**Byers Gill Solar  
EN010139**

# 3.3 DCO Schedule of Changes

Deadline 6 – December 2024

Drawing Title
Street Works, Public Rights of Way & Access Plans
Sheet 3 of 13
APFP Regulation 5(2)(k)

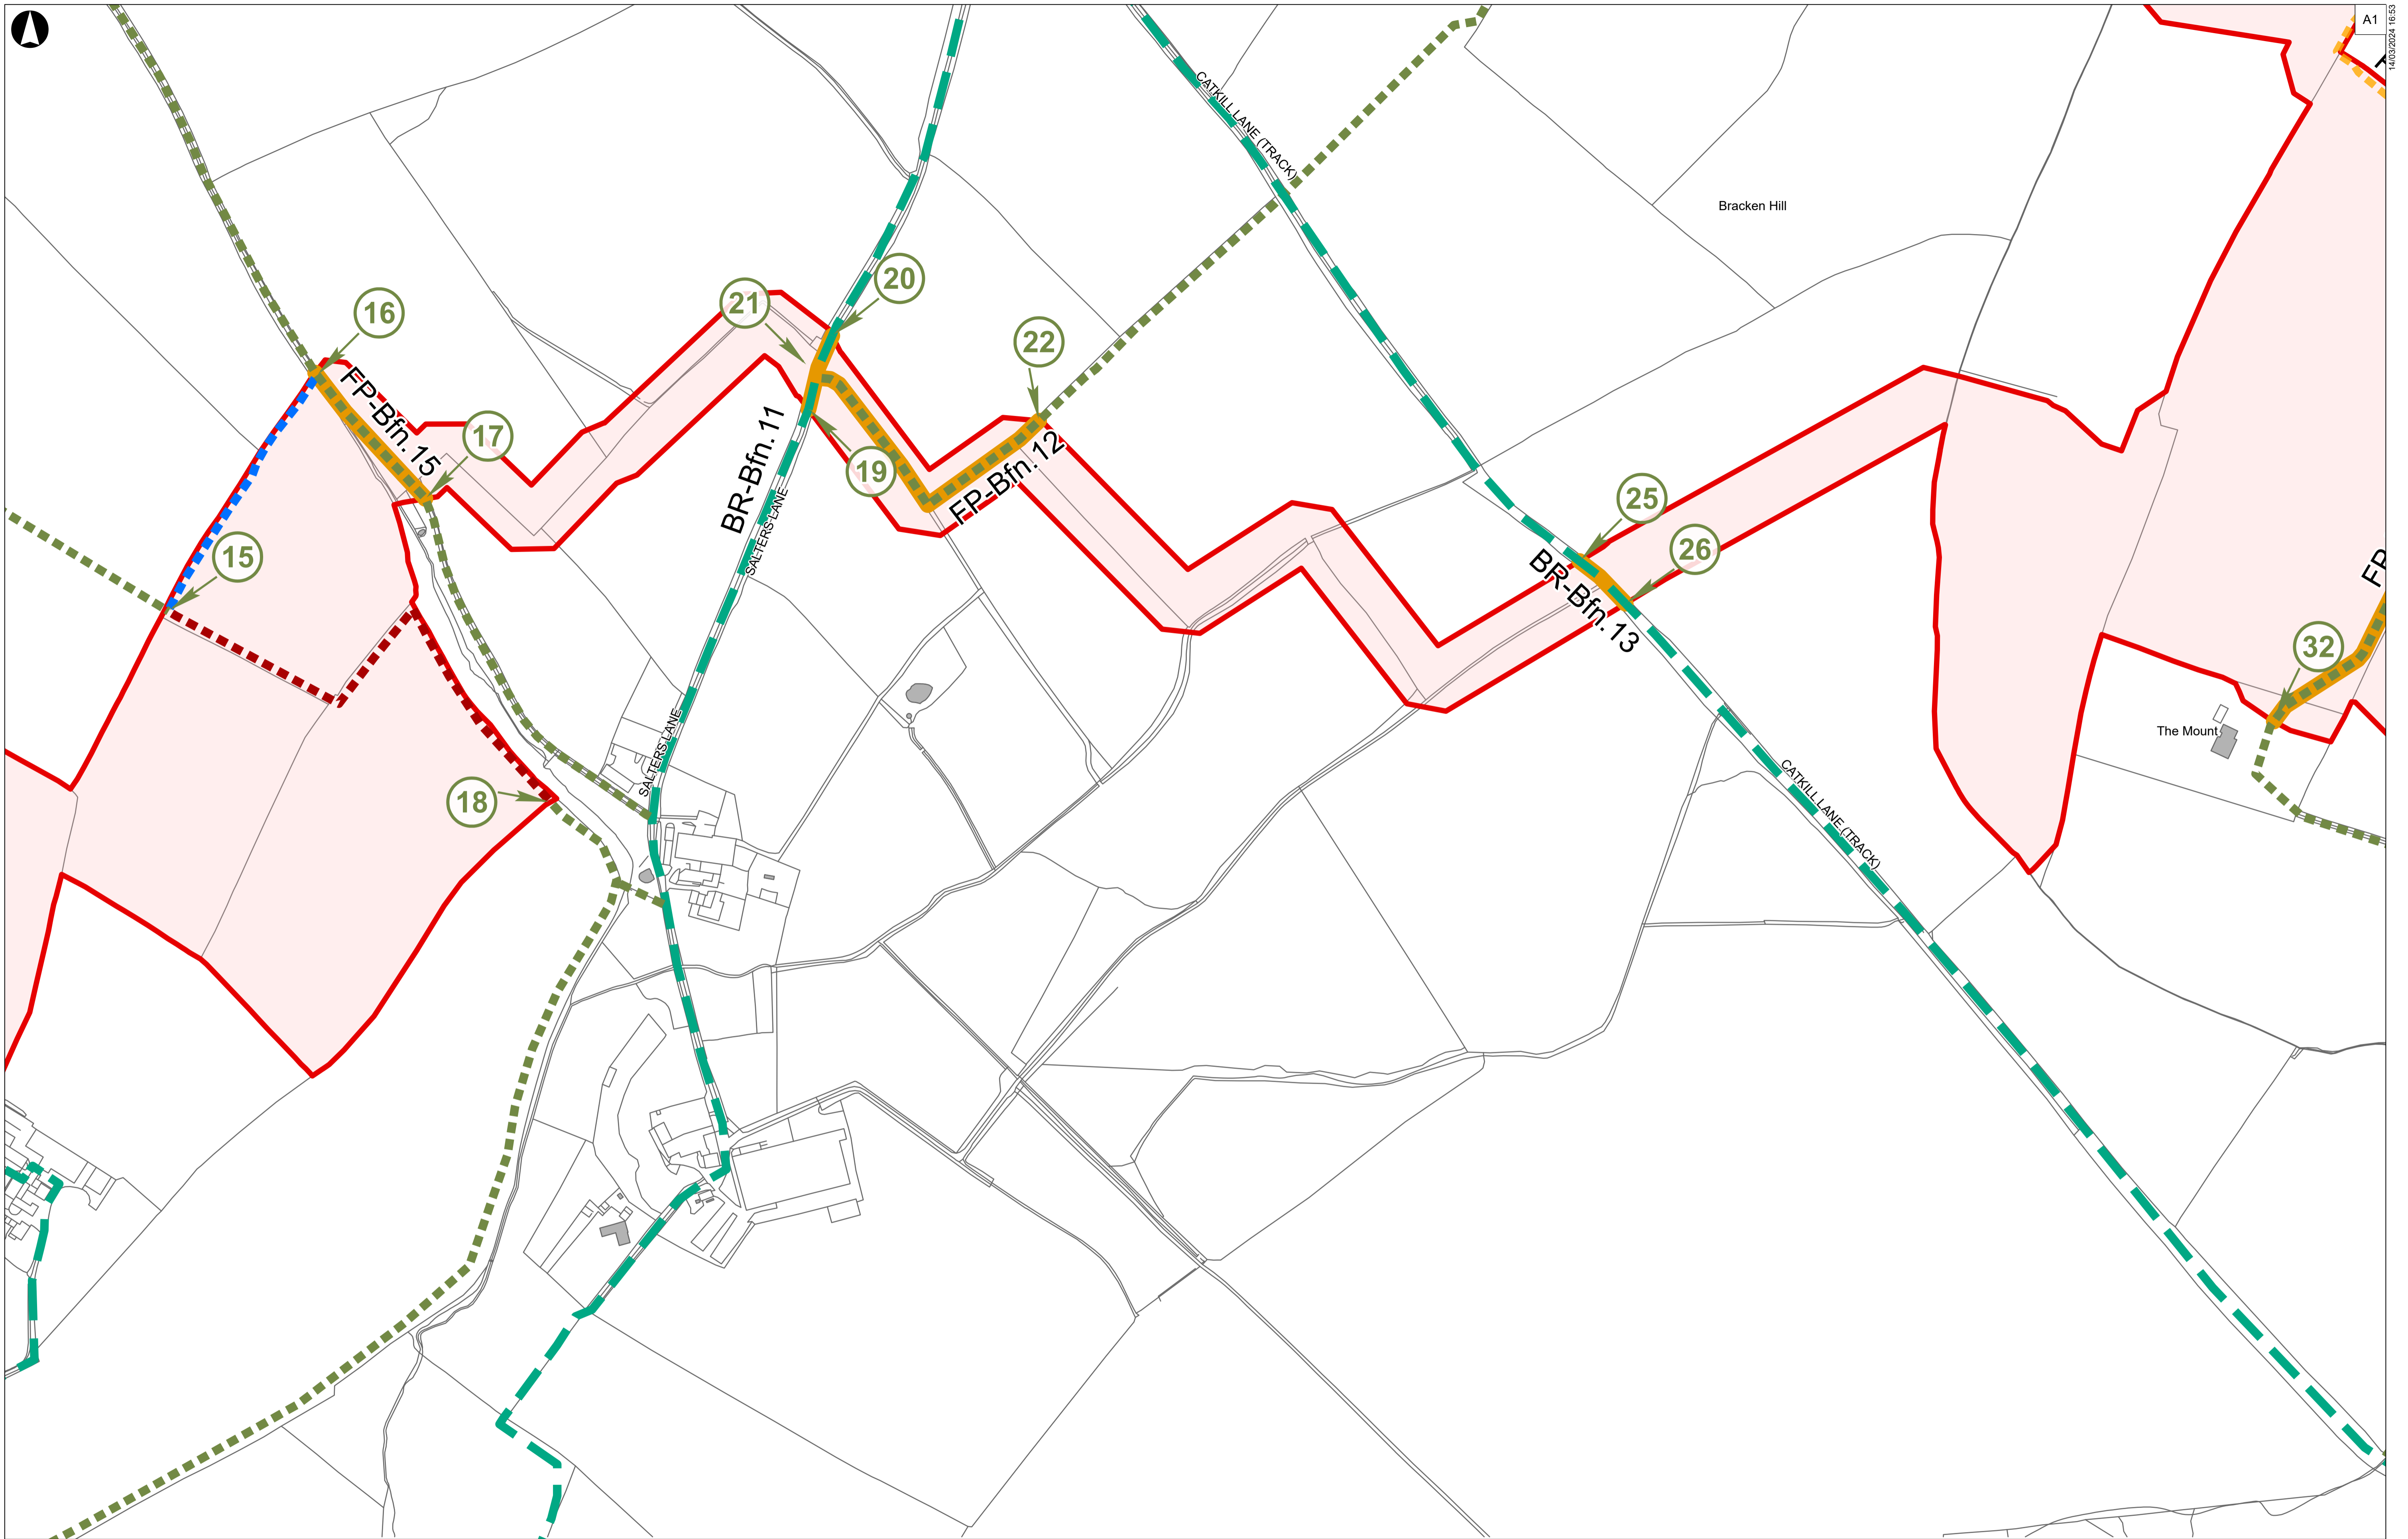
For example, row 2 of the table has been amended as follows:

Parish of Brafferton	Unnamed Road	Cable works beneath the width of <del>highway</del> <u>street</u> comprising a length of 320m as shown between points marked A and B on sheet 3 of the street works, public rights of way and access plans.
----------------------	--------------	---
